OBSERVATION/SUBMISSION TO PLANNING APPLICATION

Case Reference: 324113

Re: Observation to the proposed development of open-cycle gas turbine (OCGT) and generator with ancillary equipment.

Location: Pollnagroagh and Rathmorrissy (Townlands), Athenry, Co. Galway

Purpose		PLANNING			
Title		SITE ACCESS SIGHTLINES			
Original Scale	Design/Drawn	Checked	Authorised		
SHOWN at A1	PS	ND	AJB		
Date	Date	Date	Date		
01.12.25	01.12.25	01.12.25	01.12.25		
Status	Drawing Number	Rev			
A2	PEK3-ATK-ZZ-01-DR-CE-901200	0

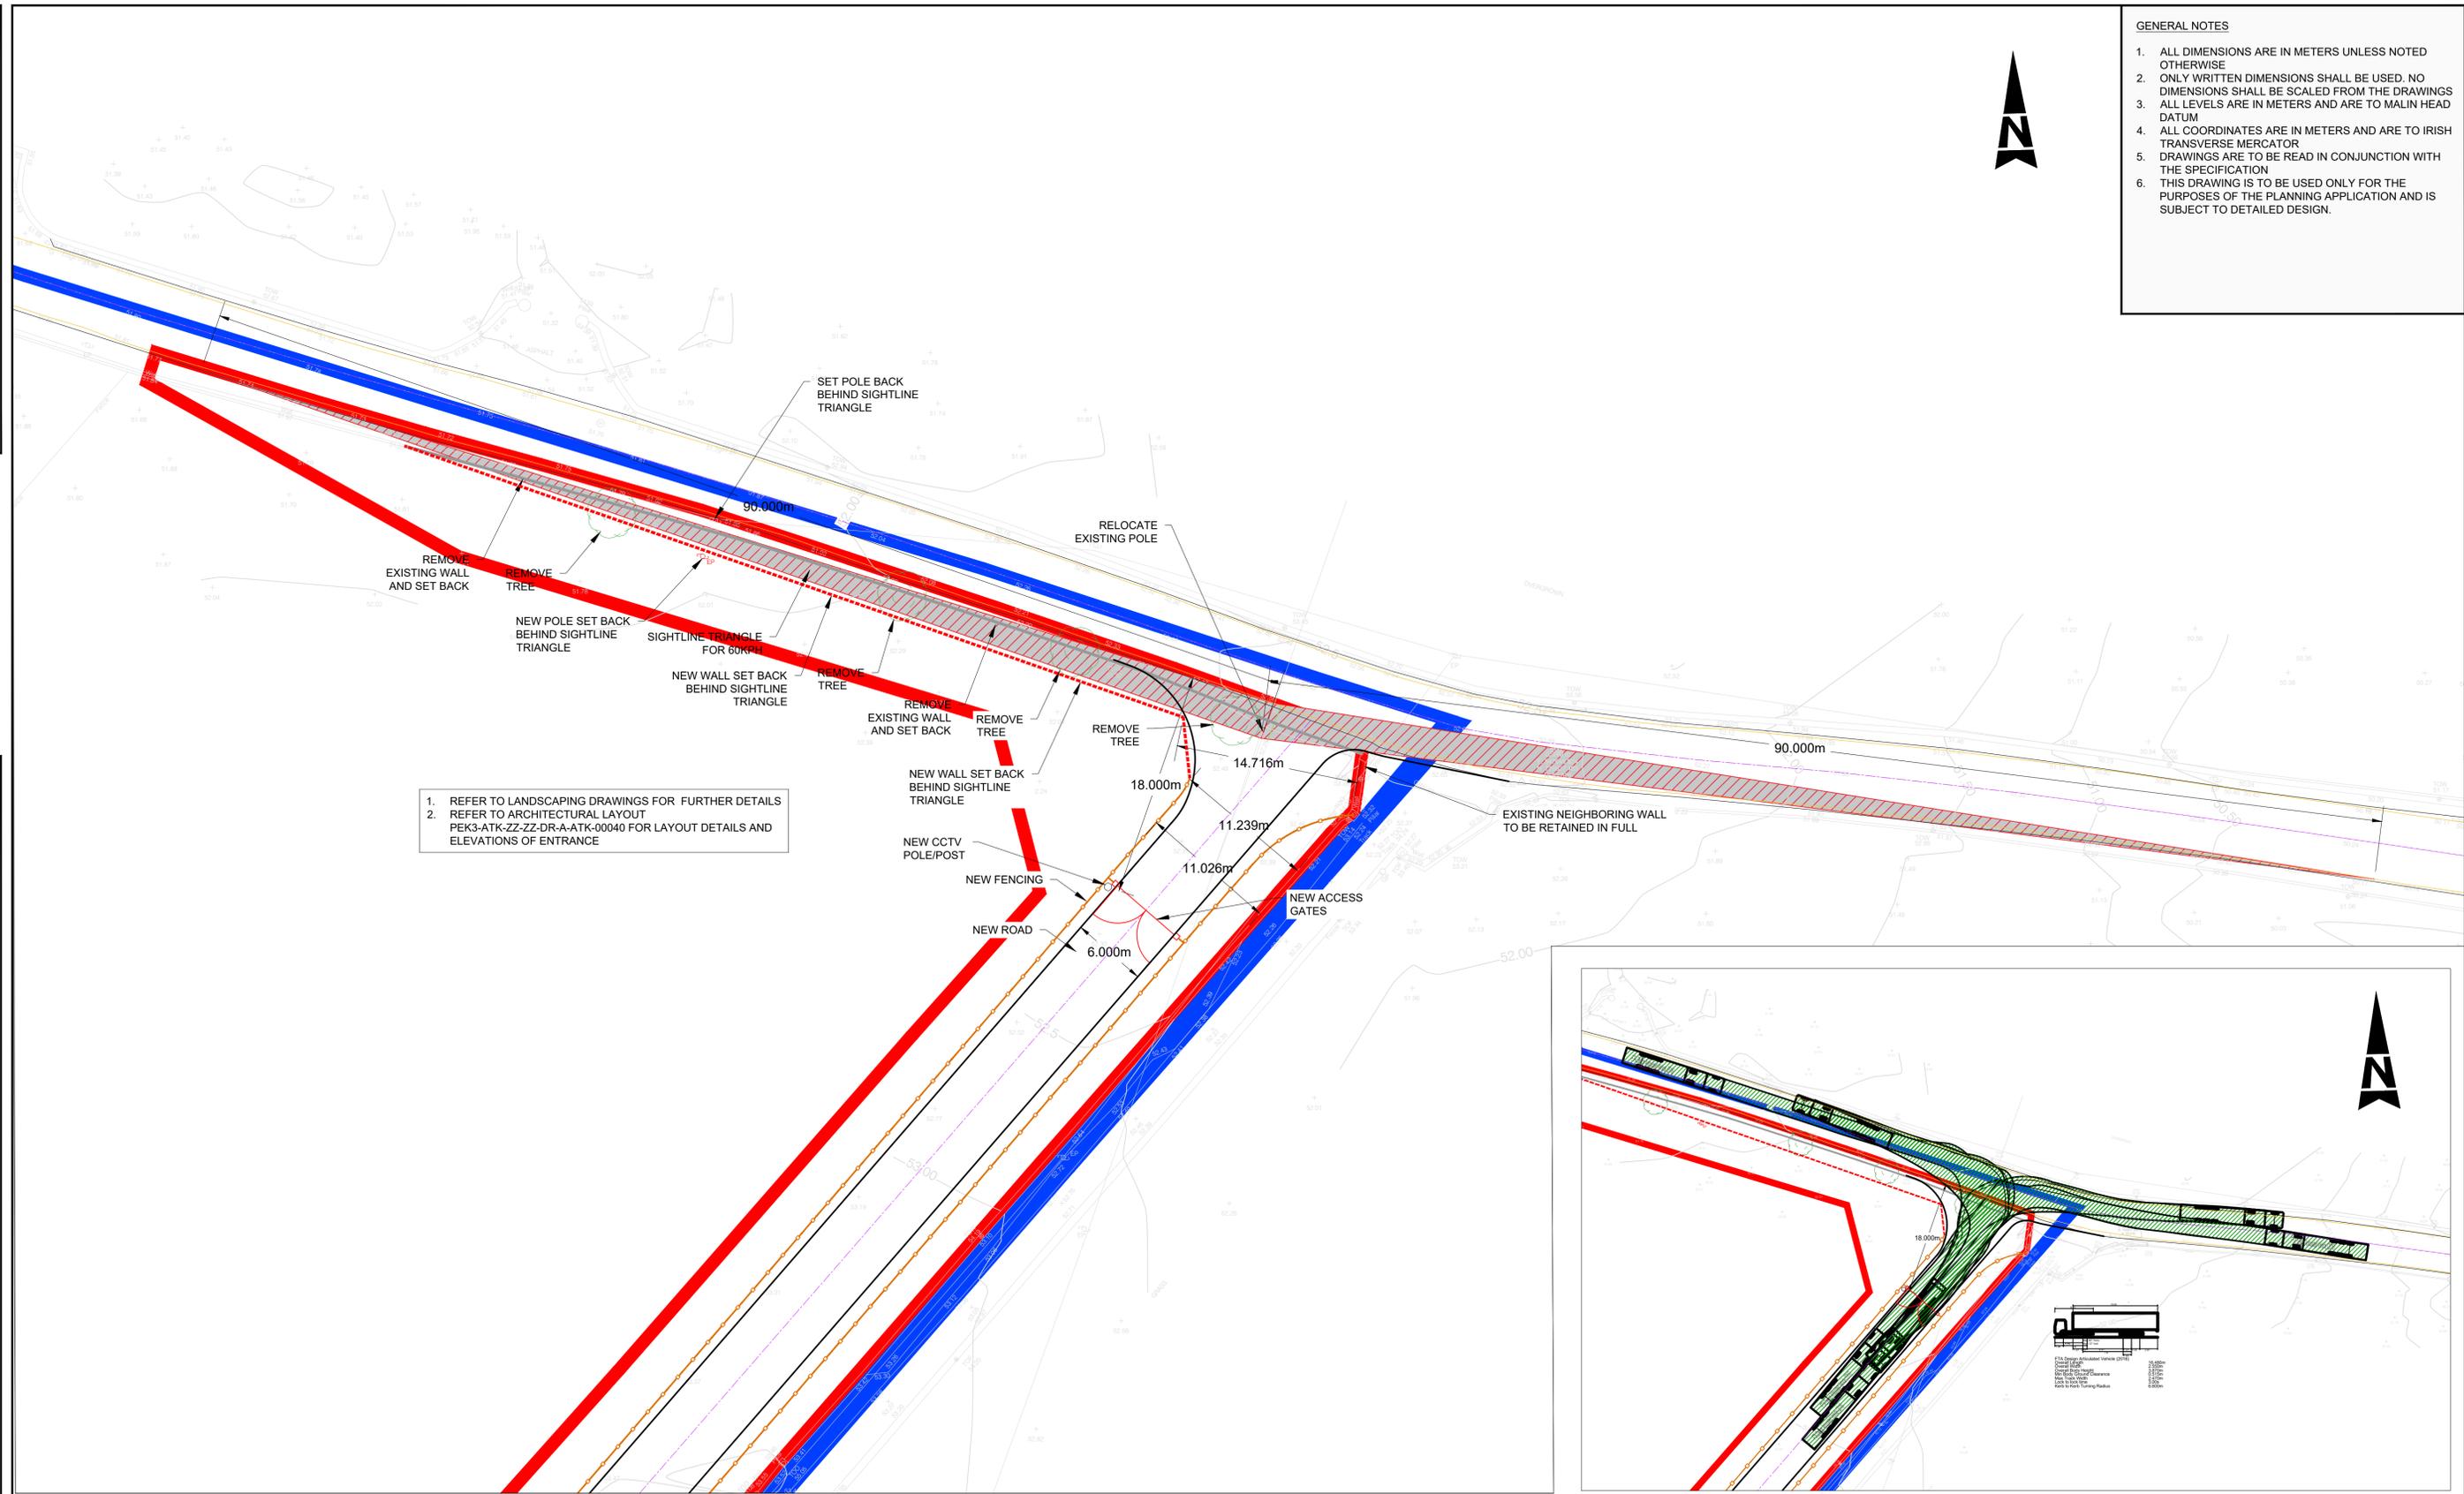
As someone who lives locally and uses this road, I am concerned about road safety in relation to the proposed entrance on the L3103. This stretch of road is already extremely narrow, with no hard shoulder, making it difficult for two heavy goods vehicles to pass safely and leaving no margin for error. Visibility is also poor due to blind dips and sharp bends, meaning drivers often cannot see oncoming traffic in time. The proposed development would increase traffic levels, including heavy goods vehicles, construction traffic, and fuel deliveries such as diesel tankers, all of which require space and clear sightlines that this road does not provide.

As someone who lives locally and extensively uses this road, I am concerned about the proposed location of the site entrance on the L3103. This section of road is already extremely dangerous, as it is narrow, has no hard shoulder, and does not provide sufficient space for two heavy goods vehicles to pass safely. Visibility is also poor due to blind dips and sharp bends, meaning drivers often cannot see oncoming traffic in time, and introducing a site entrance at this location would significantly increase the risk to all road users.

The placement of a site entrance at this hazardous location on the L3103 raises serious safety concerns. The road is already constrained by its narrow width, the absence of a hard shoulder, and extremely poor visibility due to blind dips and sharp corners, yet the Environmental Impact Assessment does not appear to fully
